From: Contact Centre (CRM) <contact@ribblevalley.gov.uk>
Sent: 28 January 2024 09:46
To: Planning
Subject: Planning Application Comments - 3/2023/1005 FS-Case-581124602

Planning Application Reference No.: 3/2023/1005

Address of Development: Meadowcroft
Clough Lane
Chipping
PR32TP

6895 - P 02 D REV

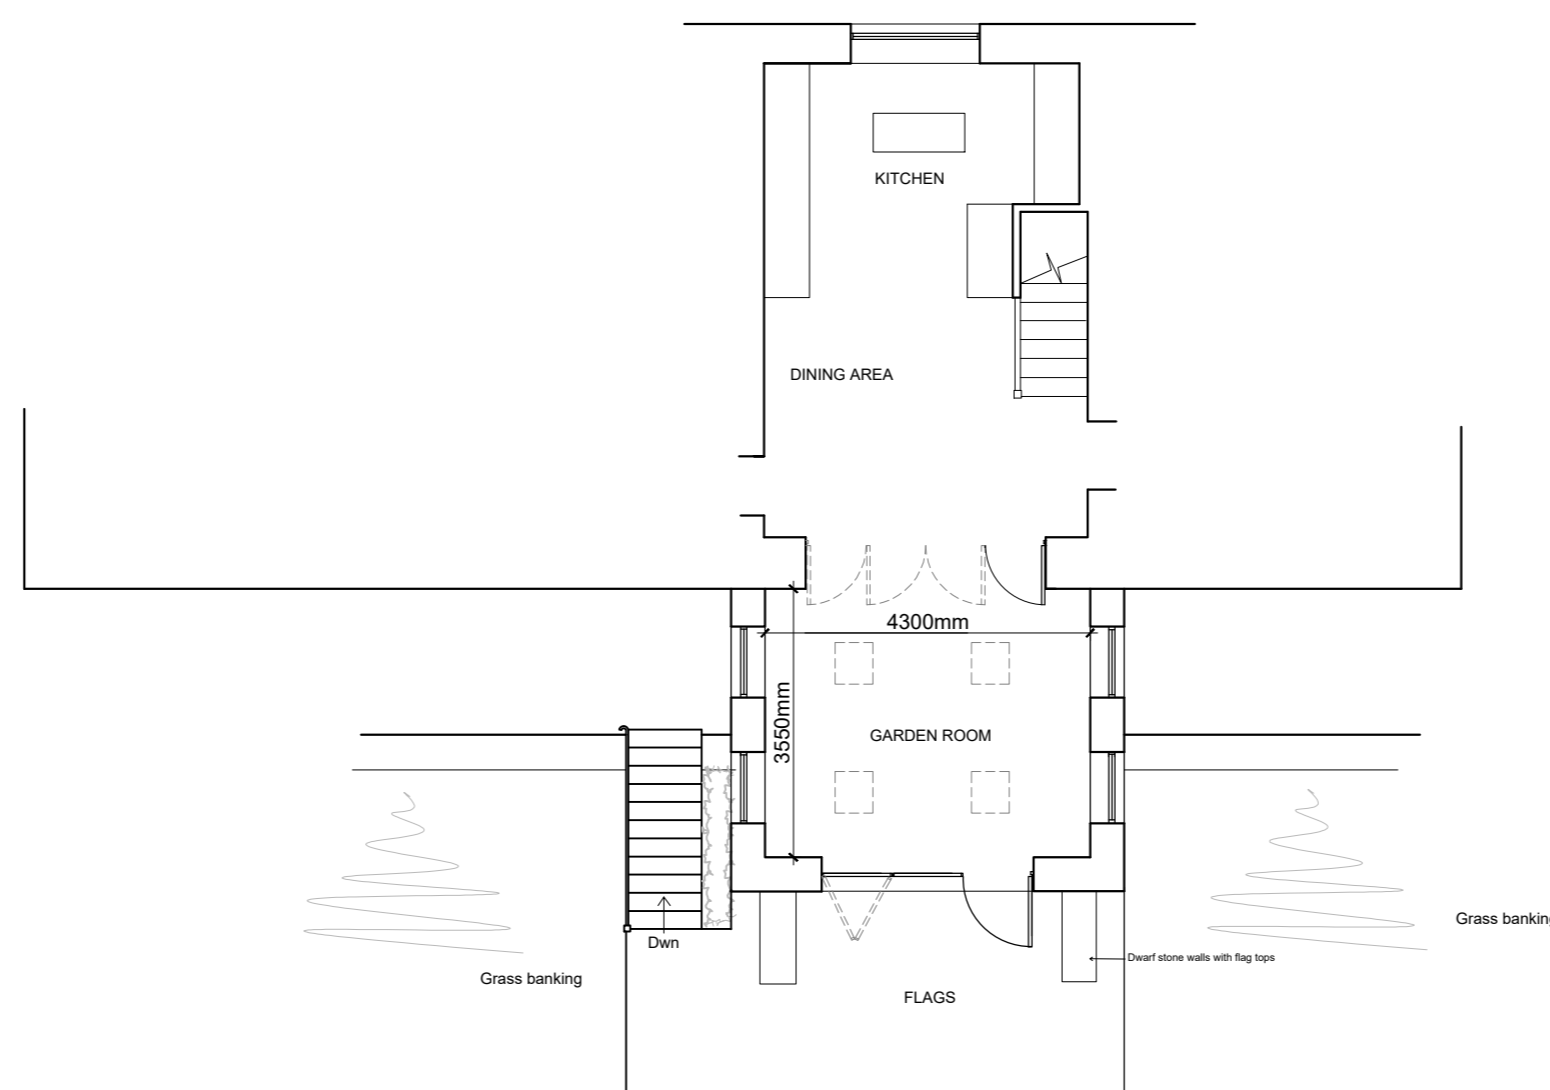
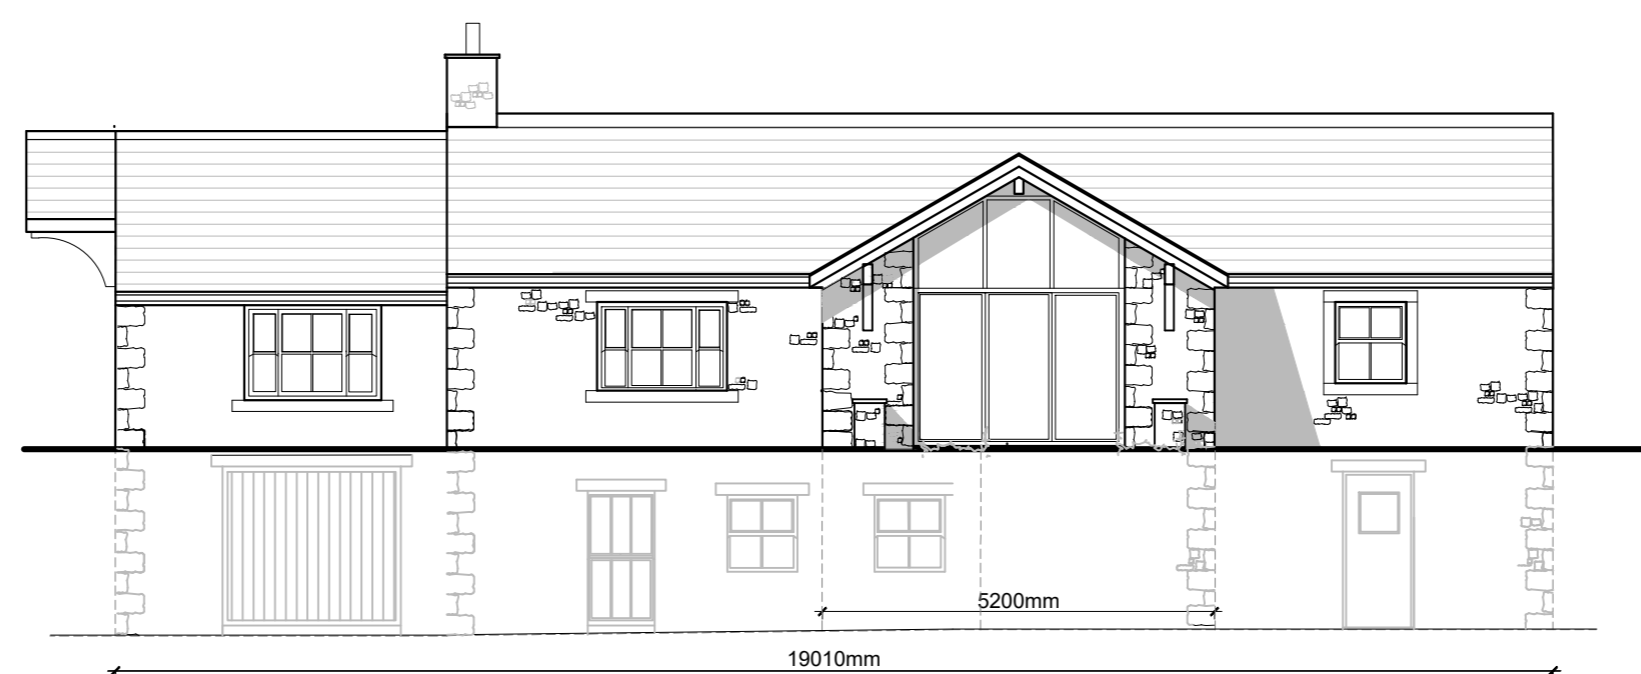
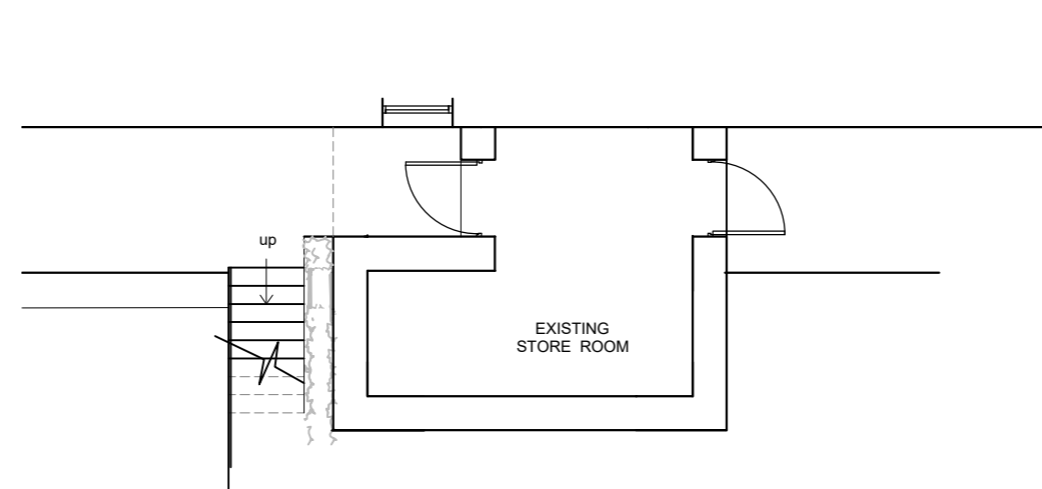
[REDACTED] We have no objections in principle to the concept of the rear extension, however we are very concerned about the outlook from the proposed windows on the side elevation.

The proposed habitable windows [REDACTED] The levels proposed would [REDACTED] [REDACTED] which is of great concern.

[REDACTED] We have no objections in principle to the concept of the rear extension, however we are concerned about the outlook from the proposed windows on the side elevation.

The proposed habitable windows [REDACTED] The levels proposed would enable [REDACTED] which is of great concern.

[REDACTED] We have no objections in principle to the concept of the rear extension, however we are concerned about the outlook from the proposed windows on the side elevation.

The proposed habitable windows [REDACTED] The levels proposed would enable [REDACTED]
